Our ref: TR010064/Deadline 3

National Highways
Piccadilly Gate
Store Street
Manchester
M1 2WD
0300 123 5000
05/11/2024

TR010064 - M60/M62/M66 Simister Island Interchange EXAMINATION DEADLINE 3 SUBMISSIONS

FIGURE 10.1

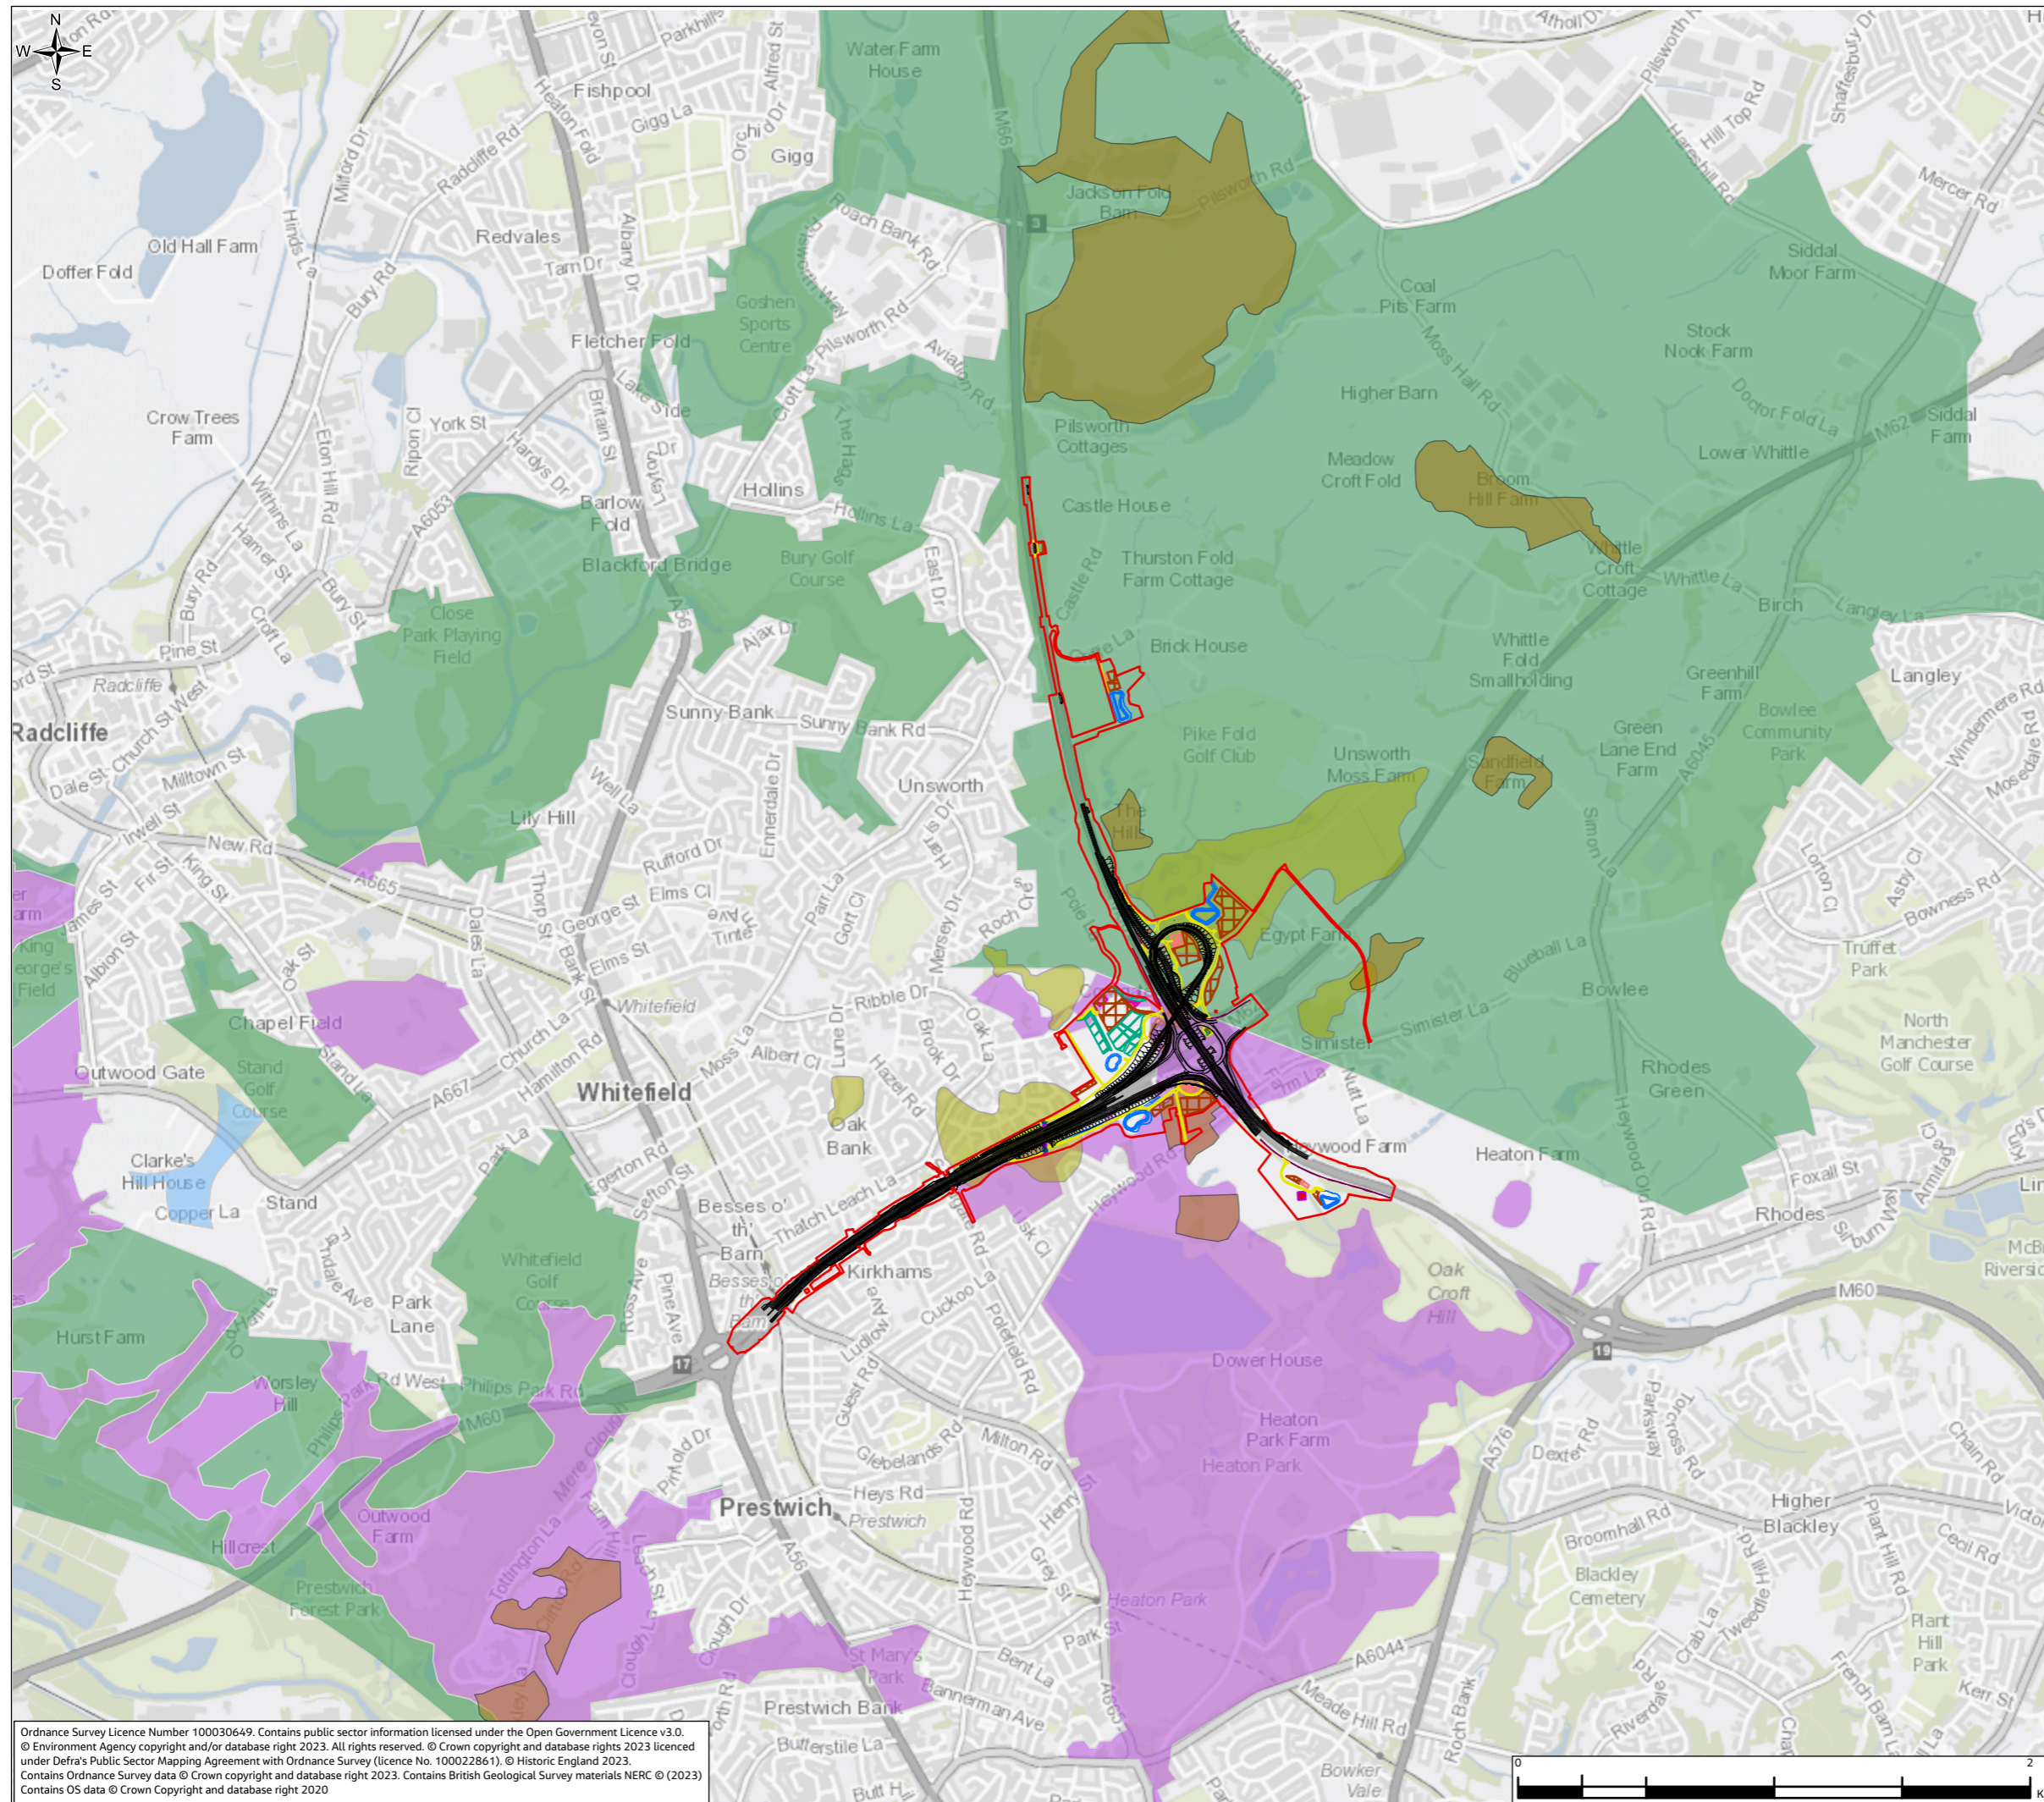
In response to ExA *MAW.1.1* the Applicant has updated Figure 10.1: Mineral Safeguarding Areas, Mineral Areas of Search and Peat Deposits of the Environmental Statement Figures [APP-070] to reduce the line thickness of some of the layers for clarity.

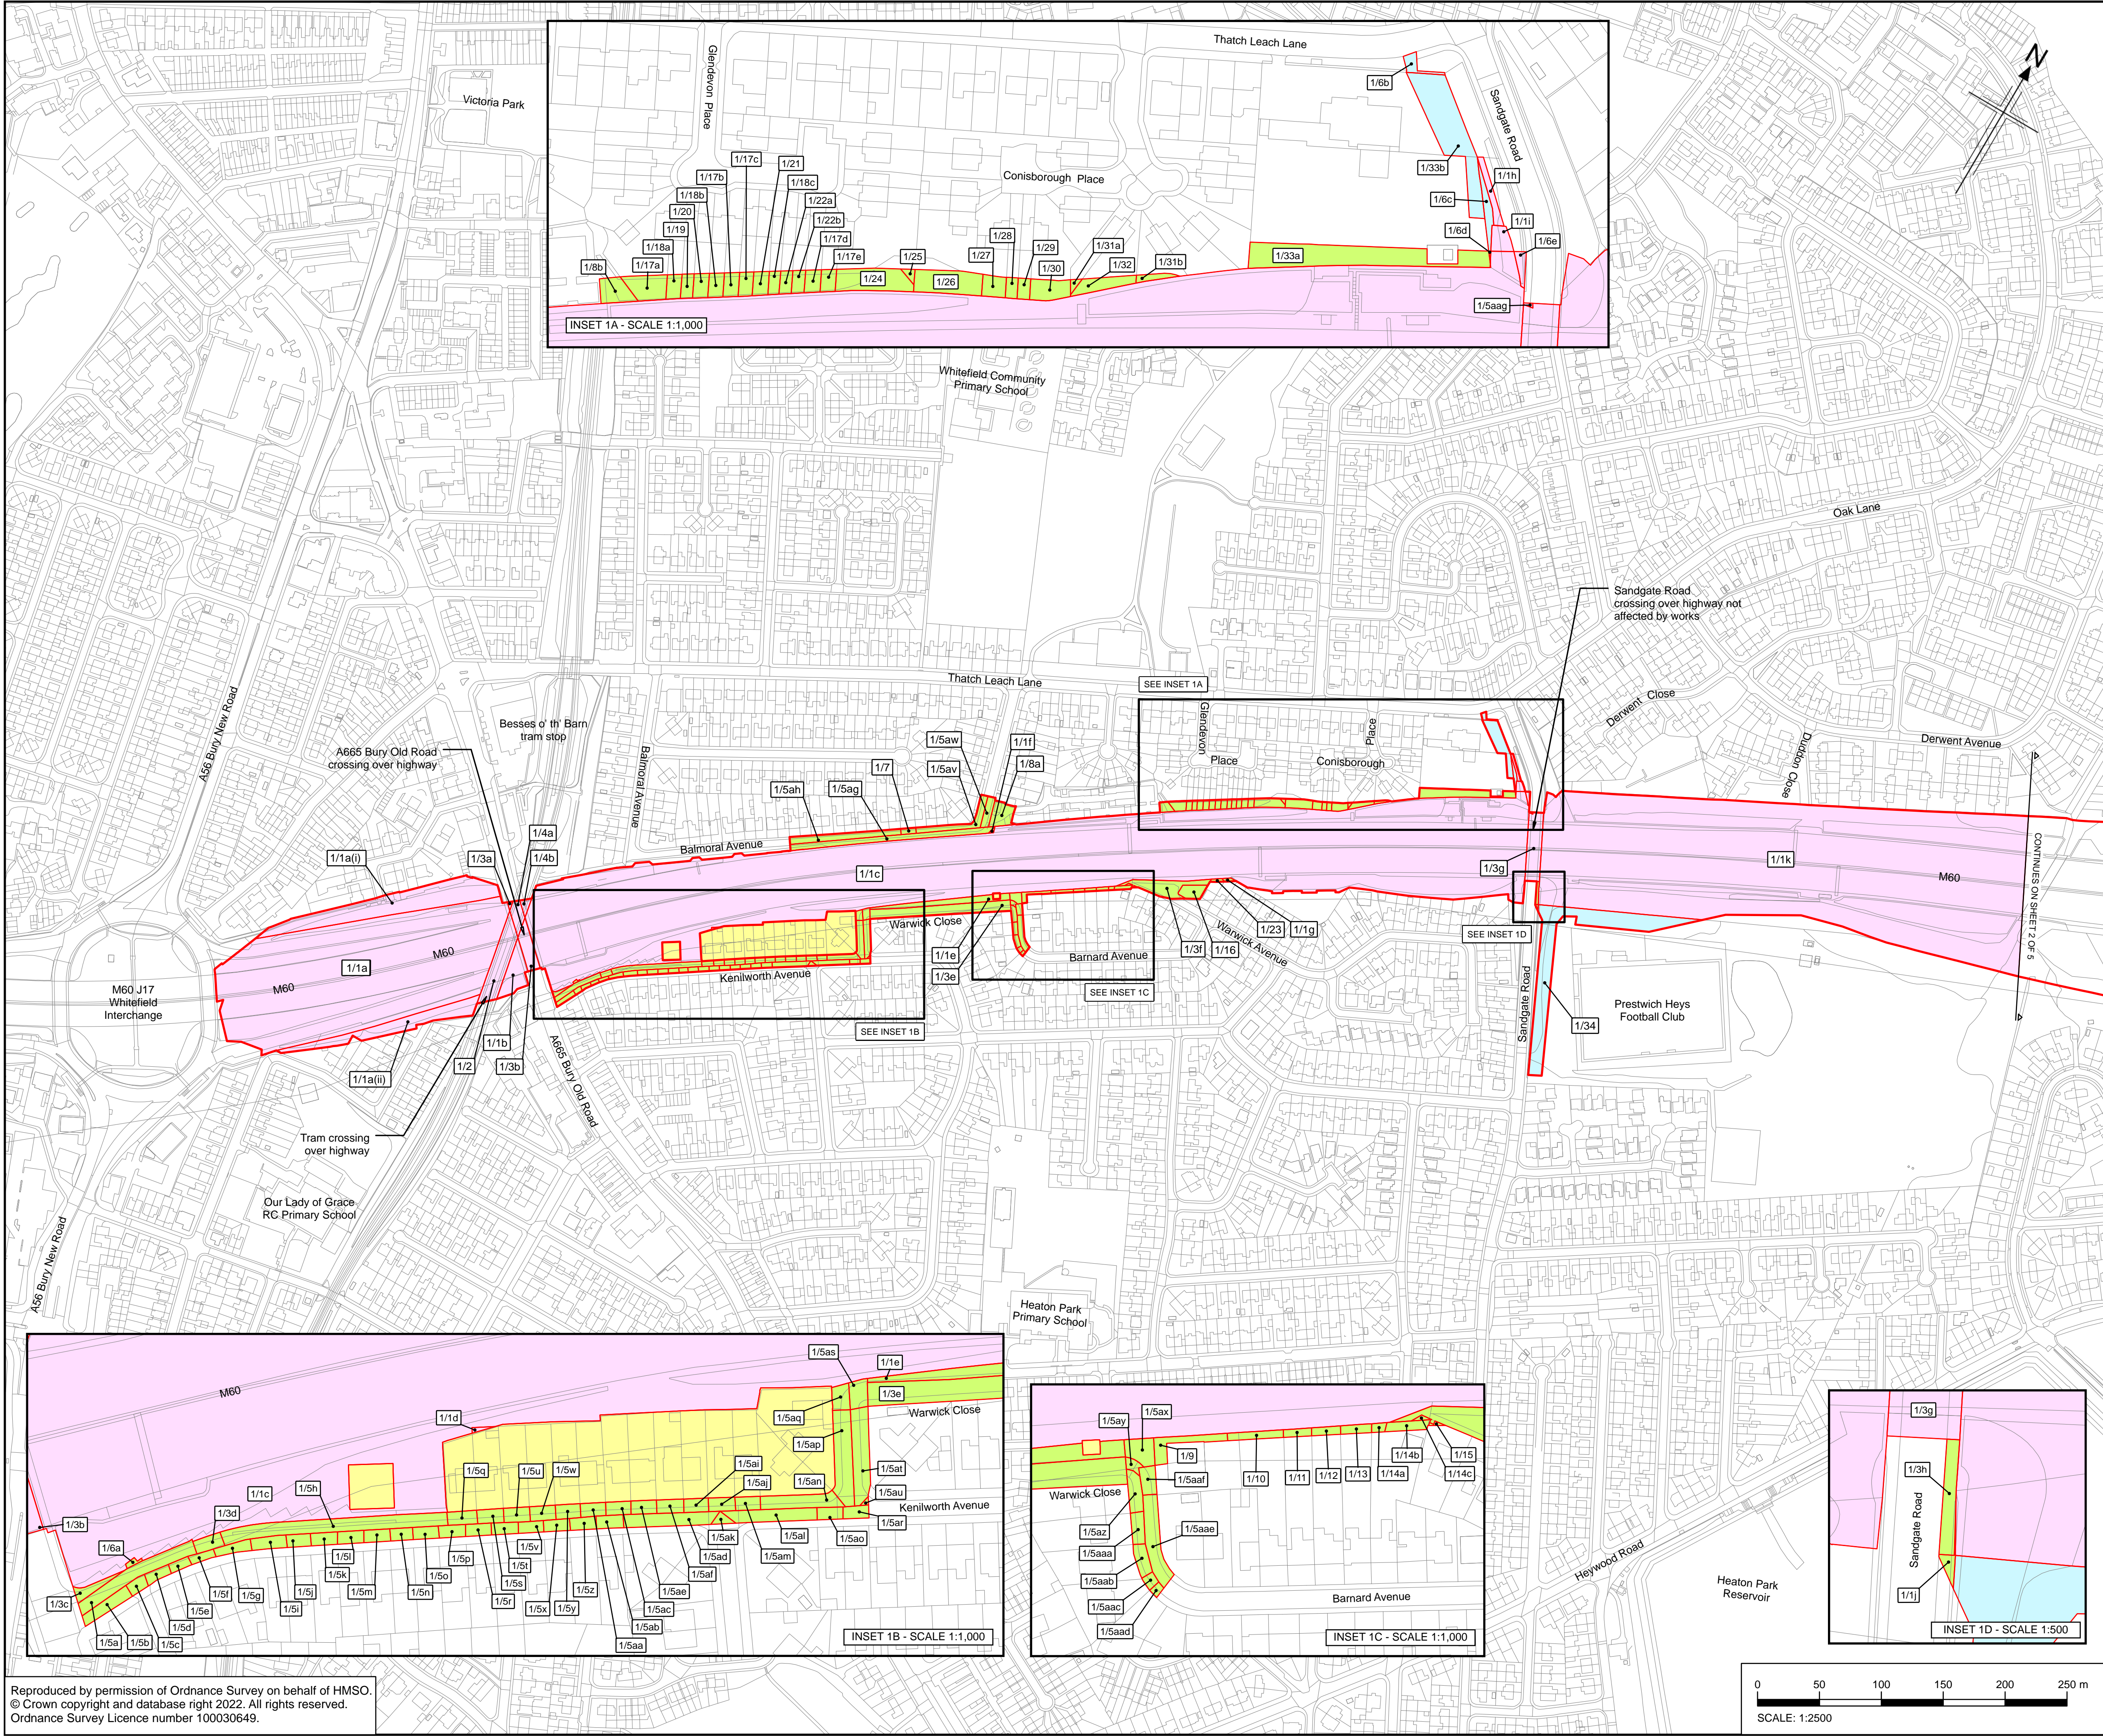
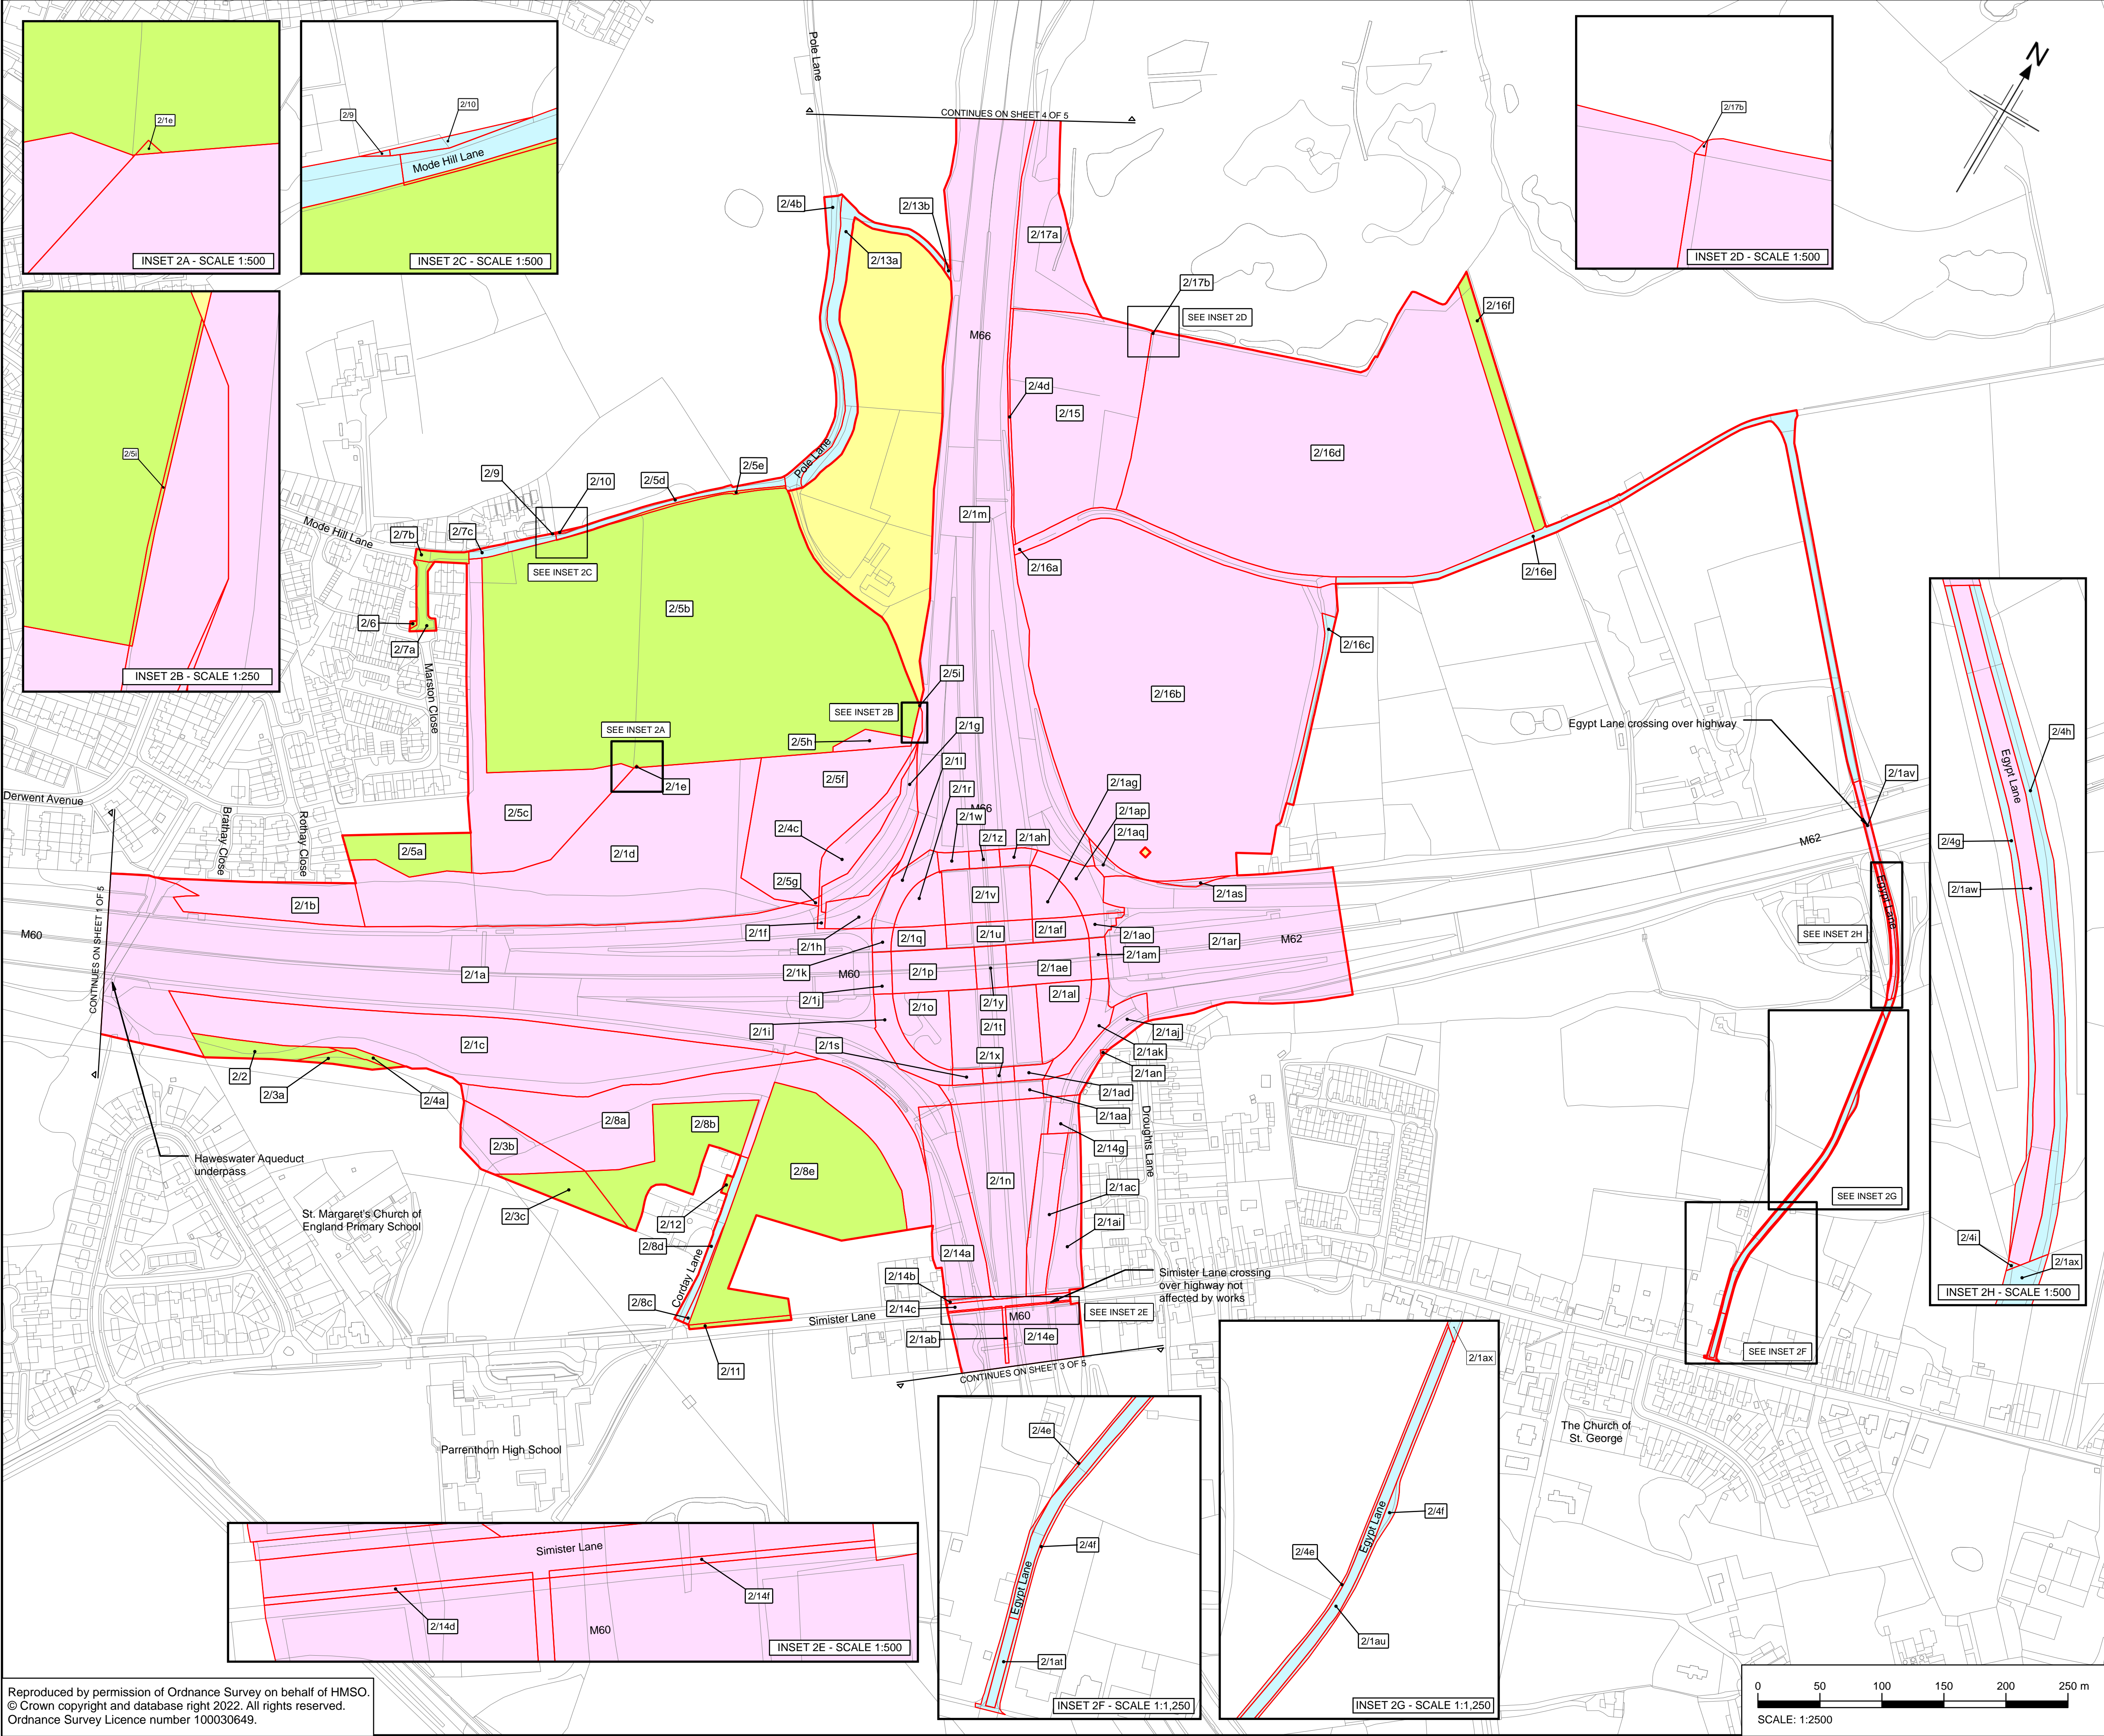
In response to ExA question *CA.1.4* revised Lands Plans [AS-005] has been provided to correctly label Plot 3/3. A further correction was identified and made to move the references for plot 2/1ax into Insets 2G and 2H.
